# **A303 Amesbury to Berwick Down (Stonehenge)**

**Secretary of State Request for  
Comments from Interested Parties**

**Wiltshire Council Response**

**August 2022**

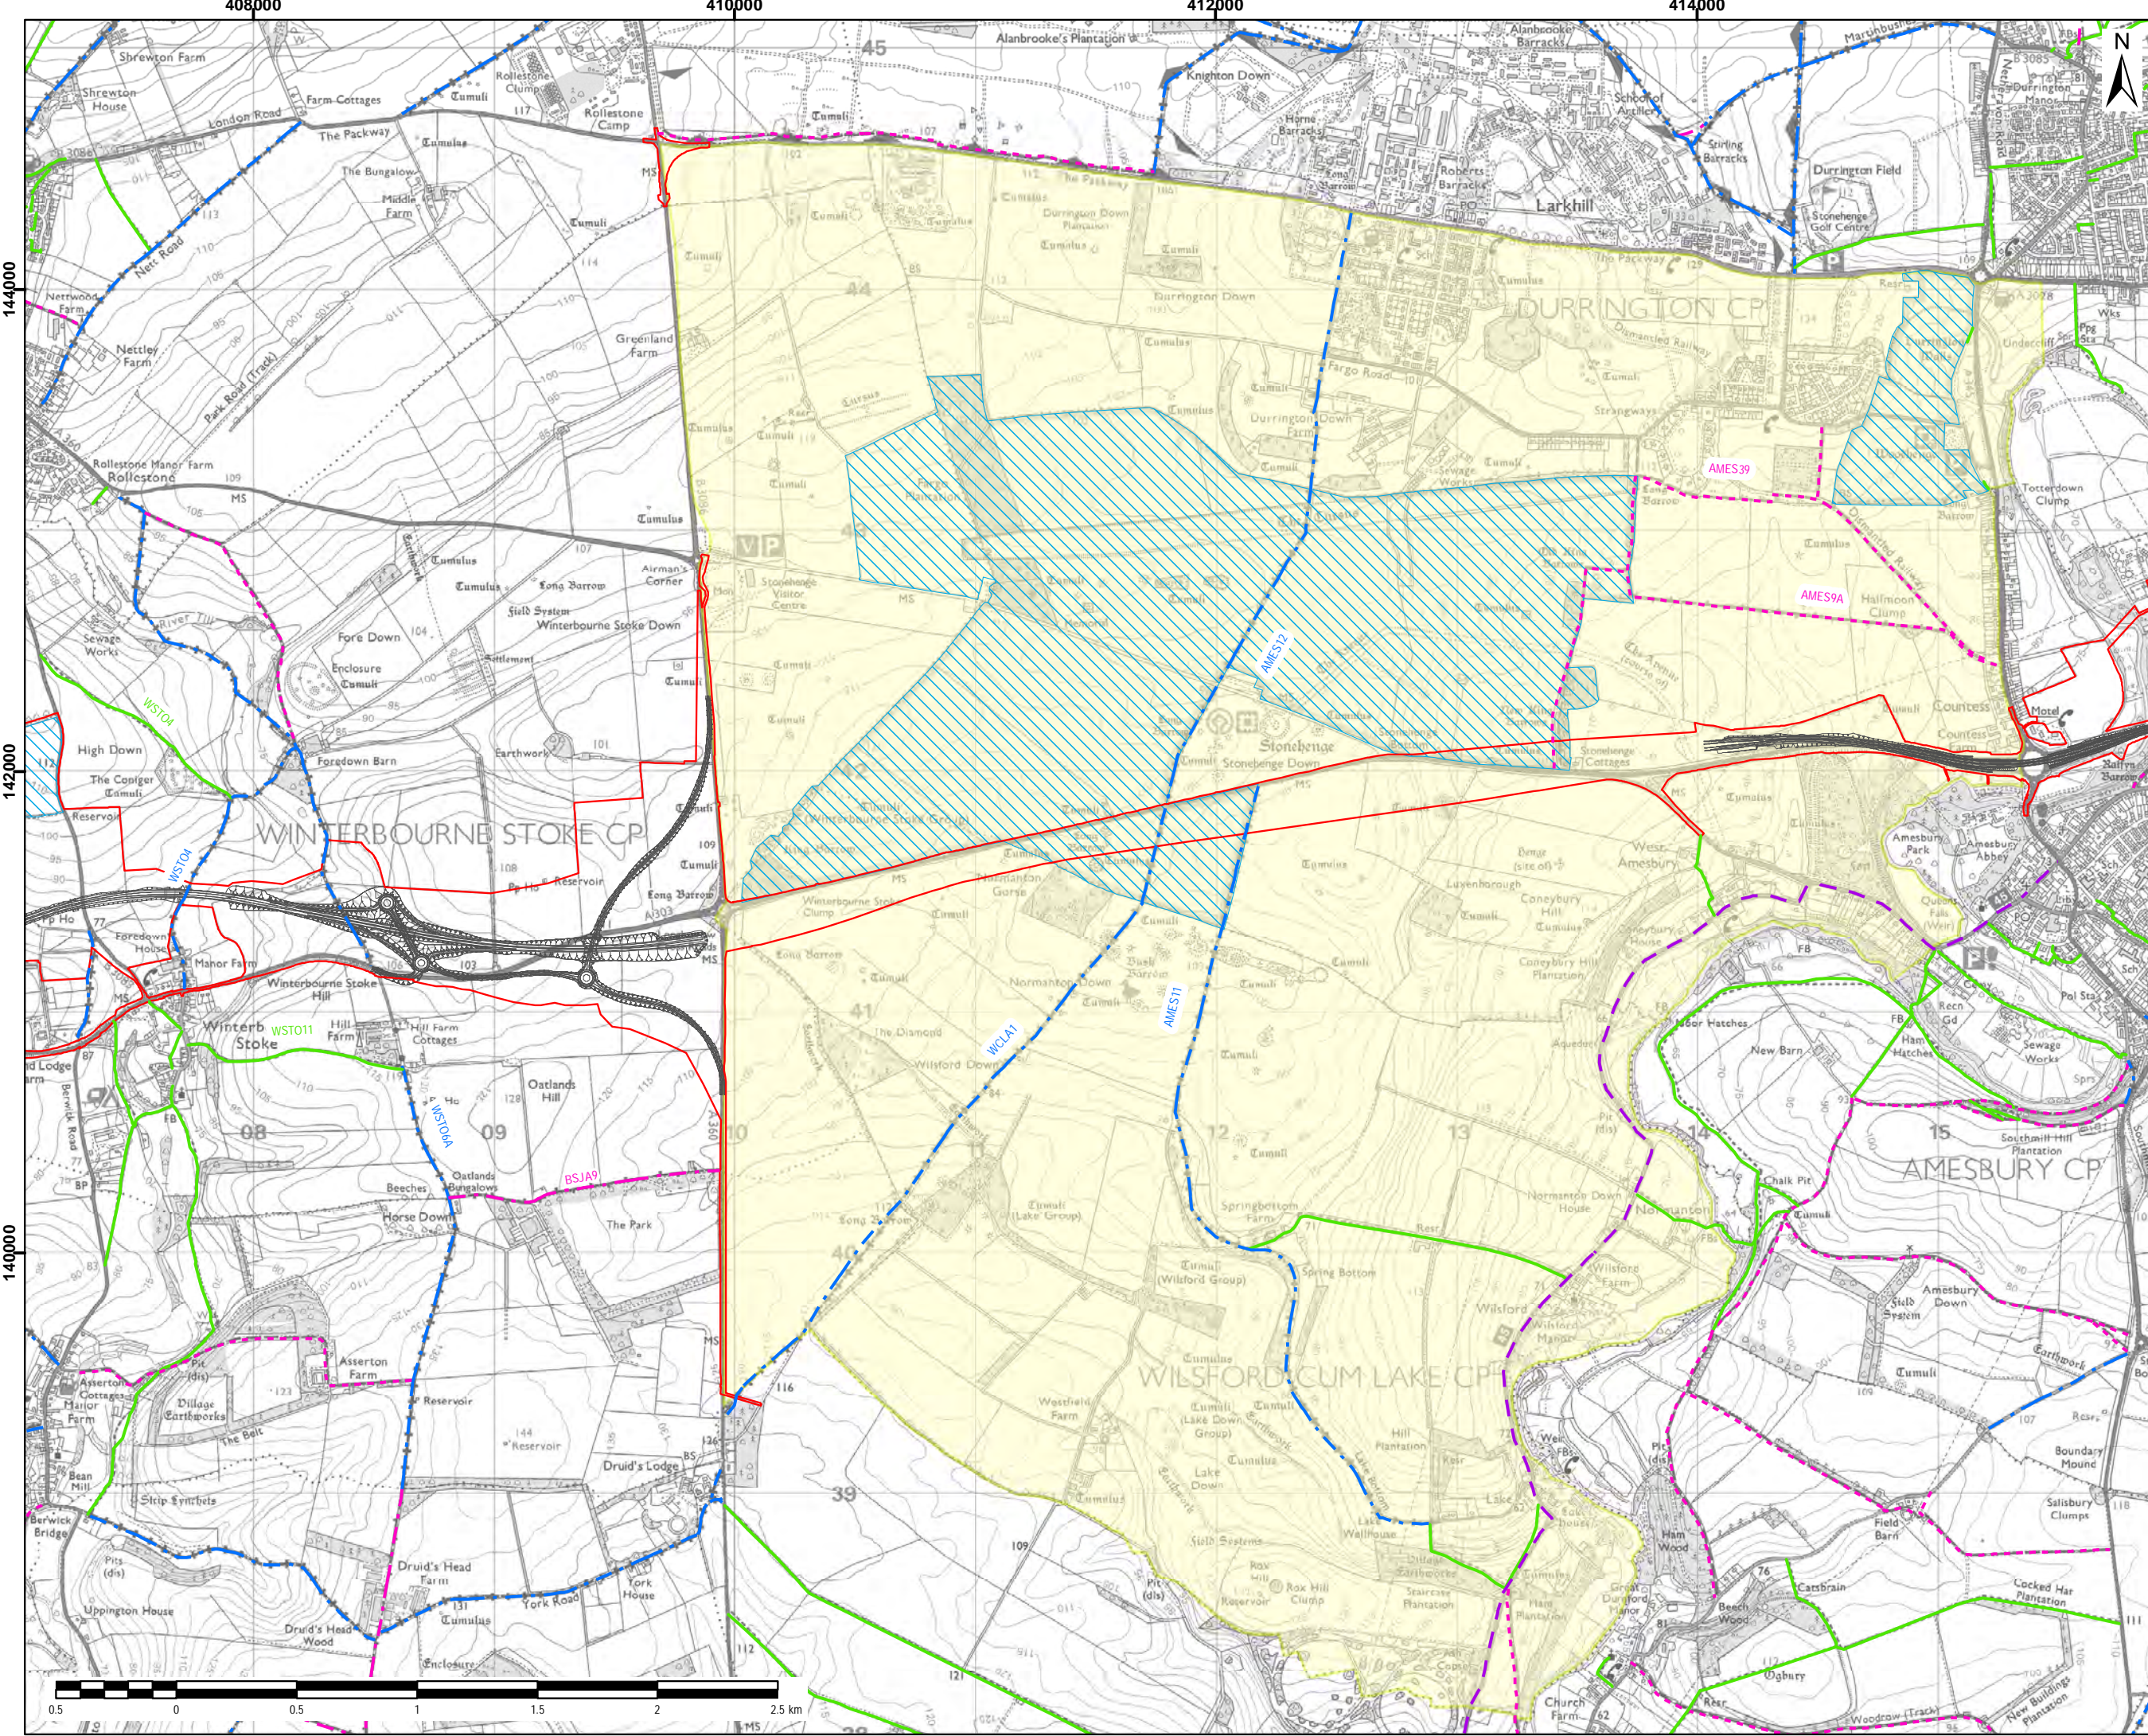
Whilst the Council considers that the use of this symbolology (or that used by the Ordnance Survey) throughout these documents would have been the most accessible approach, it is considered that Figure 11 as appended to document reference numbers Redetermination 4.3 Figures and Redetermination 4.4 Figures is reasonably clear in their representation of the route and status of the existing public rights of
